Your ref: SSD-41372302-Mod-1
File no: MOD-24-00248

11 June 2024

SSD-41372302-Mod-1: Modification 1 to Marsden Park High School and Melonba Primary School

DRAWING TITLE
PUBLIC REALM PLANS

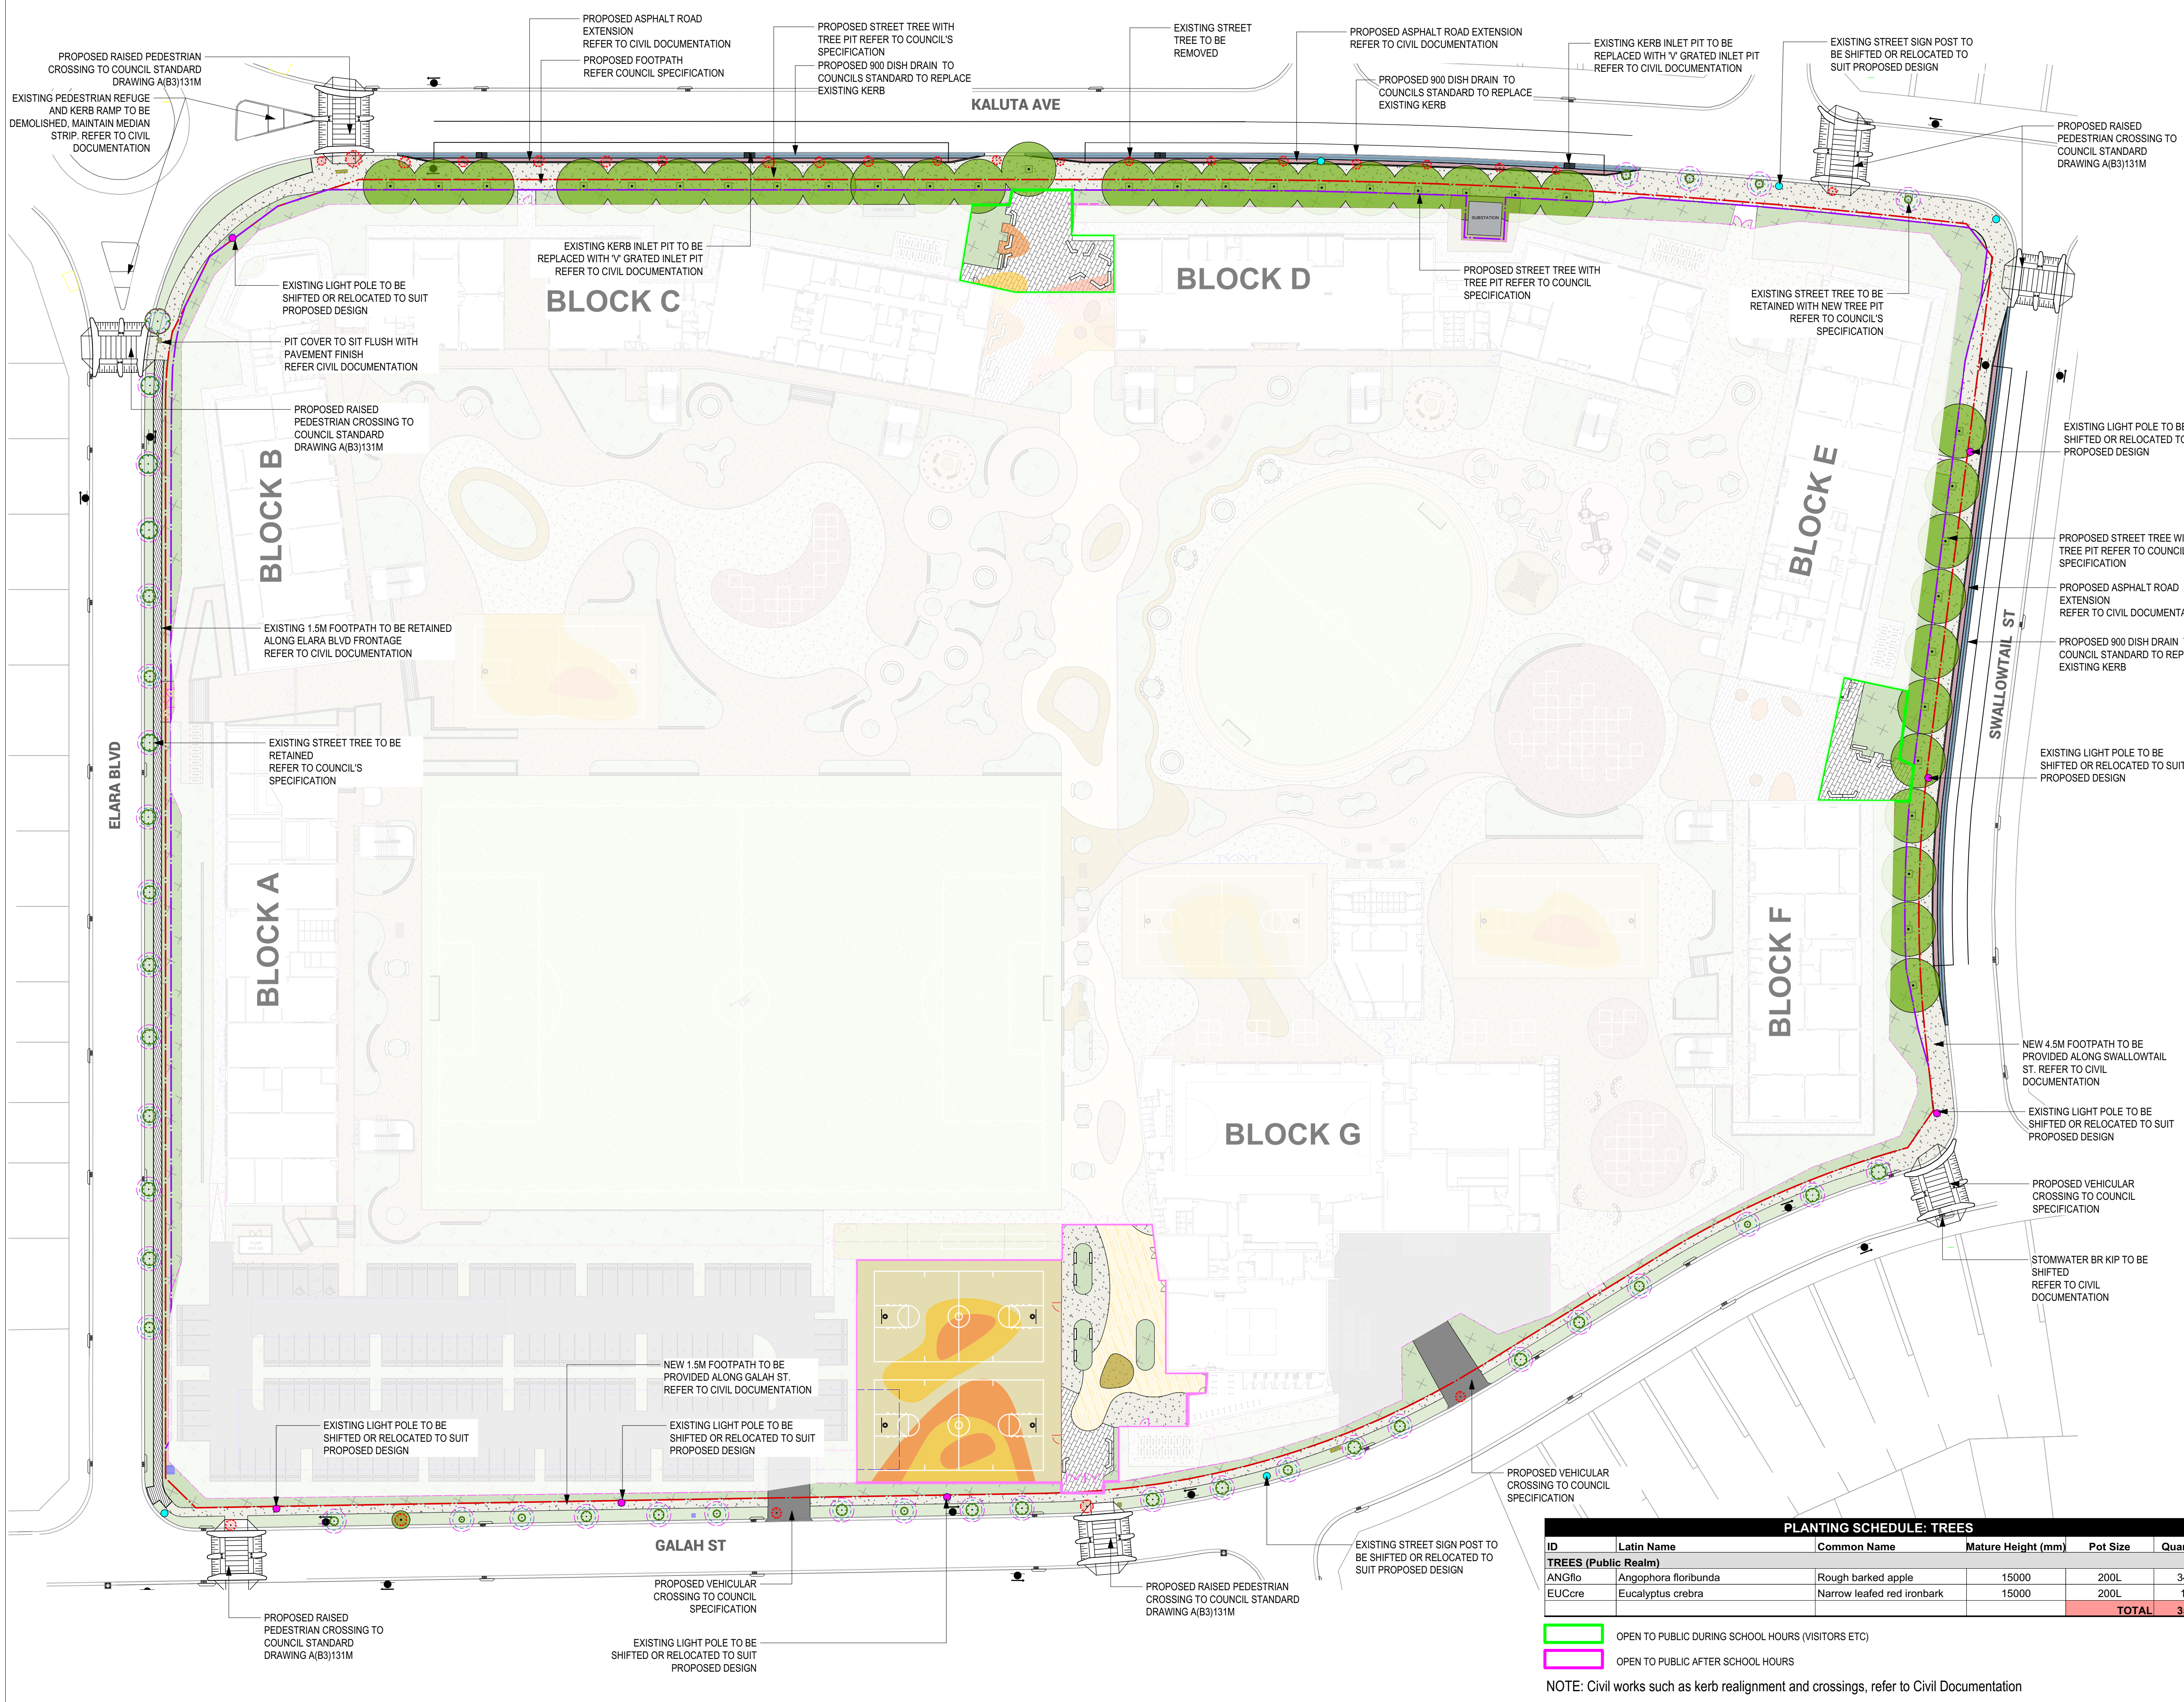
- a. Adjacent to the tree notated as L168 on the submitted Public Realm Plan, there is a change in the allotment boundary alignment. This results in a bottleneck for pedestrian movement due to the reduction in footpath width. The applicant is to relocate the tree to ensure a minimum path width of 1.5 metres is provided.
- b. The light pole notated as L170 on the submitted Public Realm Plan is proposed to be relocated directly in front of a pedestrian ramp. Per Australian Standard 1428.1 – 2009, there needs to be a minimum landing of 1.5 metres from the top of the ramp to any obstruction. The applicant is to amend the plans to address this matter accordingly.
